From: Amanda Scholes on behalf of Planning.Responses
Sent: 22 May 2018 08:32
To: Planning Scanning
Subject: FW: Y/19/18/L and Y/18/18/PL
Attachments: planning objection to garage doors.pdf

Planning Objection, with to Planning and Listed Building Consent
Planning refs. Y/19/18/L and Y/18/18/PL

To:- The Chief Planning Officer
Arun Civic Centre.
Maltravers Rd.
Littlhampton, West Sussex.
BN17 5LF

East Elevation (front)
1:100 @ A3

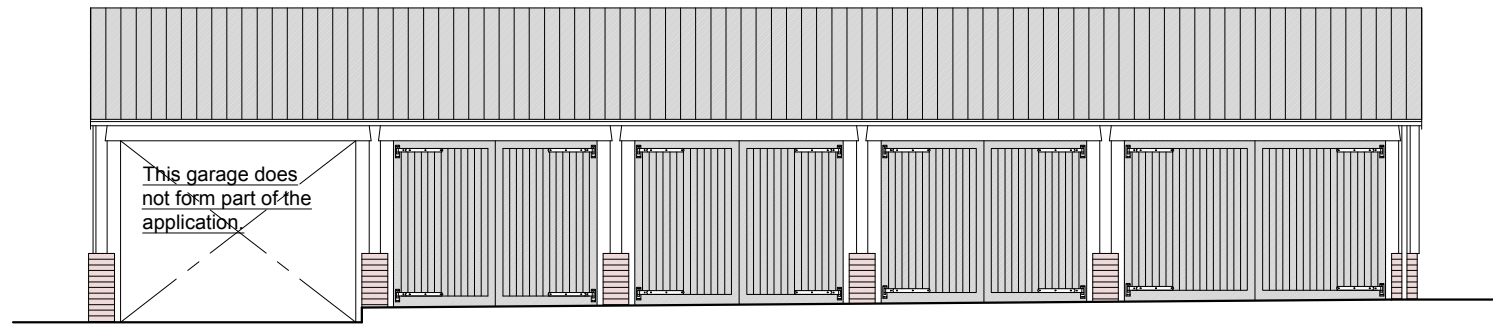
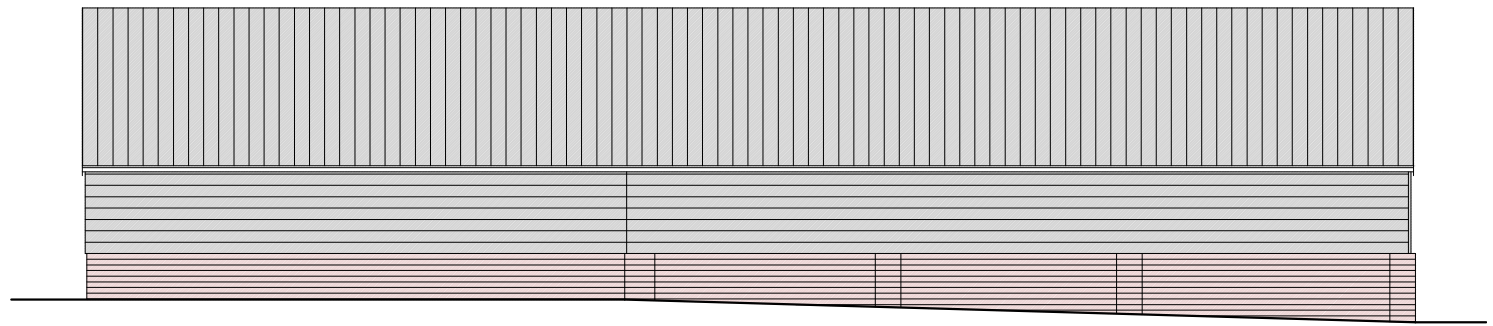
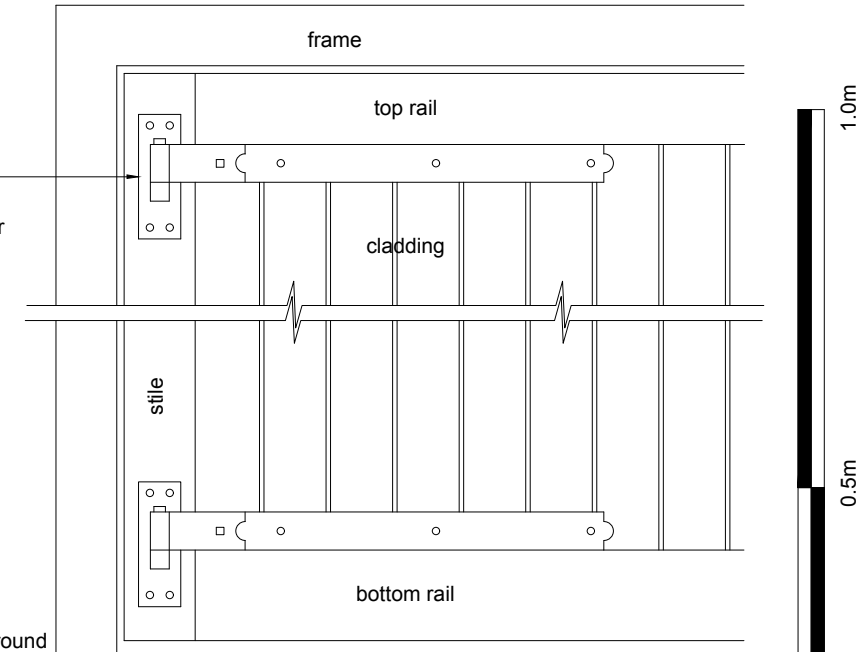
10. The style of doors in the application, have 'visible borders'.

I object on the grounds that *the borders were rejected as being non-compliant* (twice) and was stated as such, both as understood in the initial breach advice by Conservation, and by Compliance advice subsequently, that they must be plain instead (as per the original approved plan).

I object that if the application is approved, then the existing and non-compliant doors would seem, *may only require a pot of wood-stain and some door furniture to require approval.*

13 **I object** to the '*over-painting/staining*' of existing doors, as they are currently of a different type of base material to those agreed compliant, and they are already 'treated'. There is no way to be certain how this will adhere to doors already 'treated' and of a substantially different base colour. There is no guarantee that the doors would all look the same as specified, because of this.

Garages Floor plan
1:100 @ A3

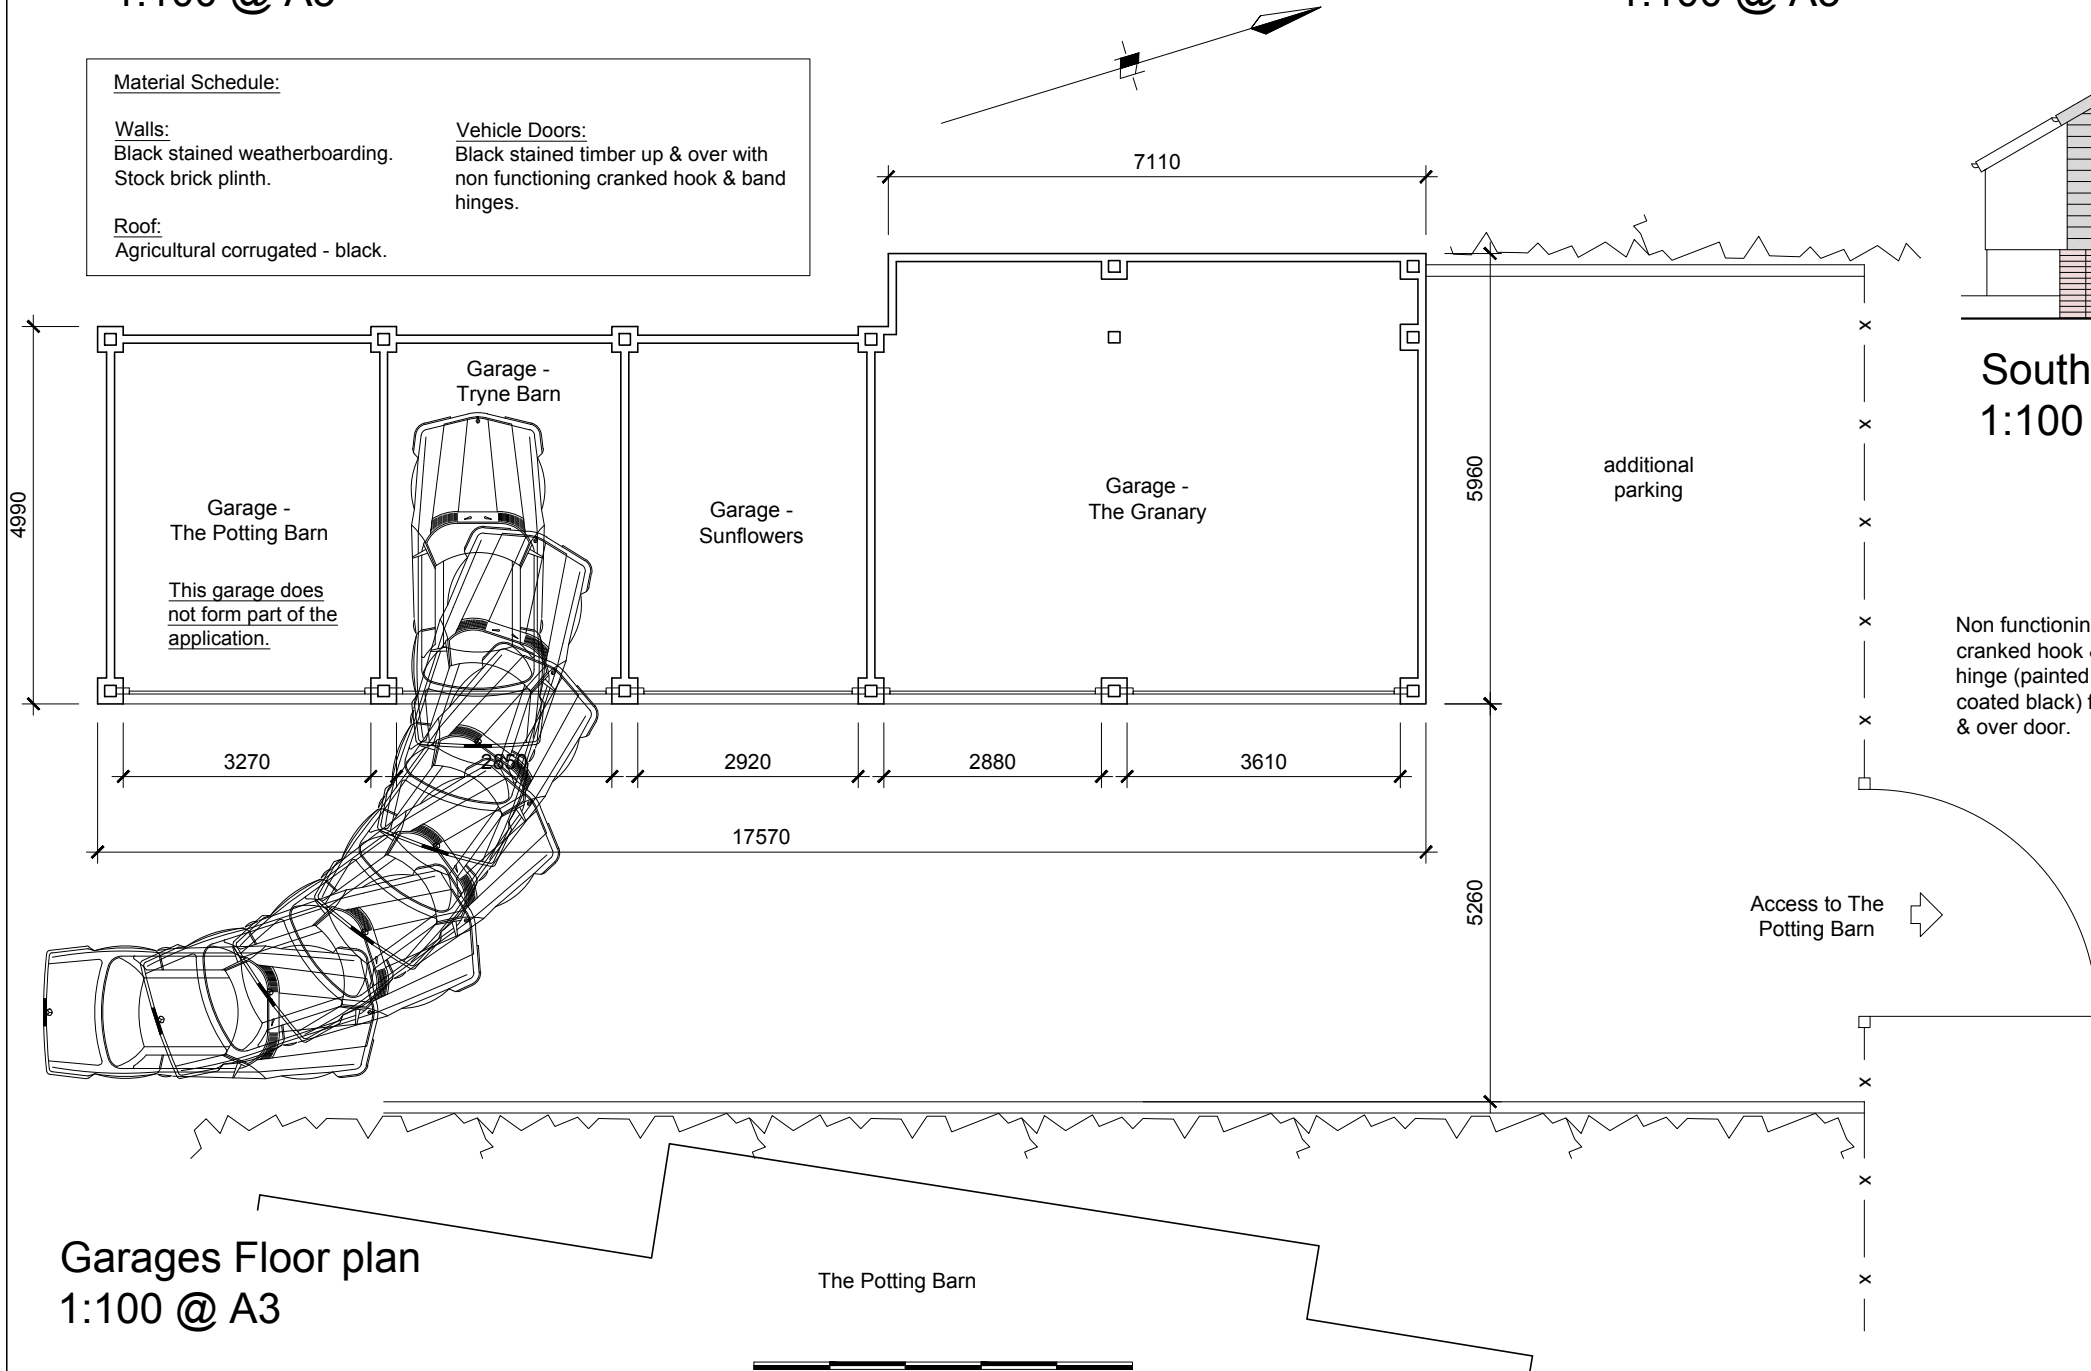
15.. **I object** to the implication that the *size of aperture for access* to garages would be difficult because of side opening doors too.

The plan supplied shows car access only in a forward direction, not in relation to reversed parking into the space, in generality, perhaps considered to be easier.

17. The measurements for openings to garages for 2 garages in the application are of apparently similar size.

The third and fourth garages are seen to be 2880 and 3610. The latter being considerably larger than any on the block for ease of access. With a combined total of 6,490, and whereby no wall between the two garages exists, **I object**, on the basis that *this should be more than adequate* to access, to the diagonal if necessary. The garage with wider doors also has additional depth, which is not universal to all garages.
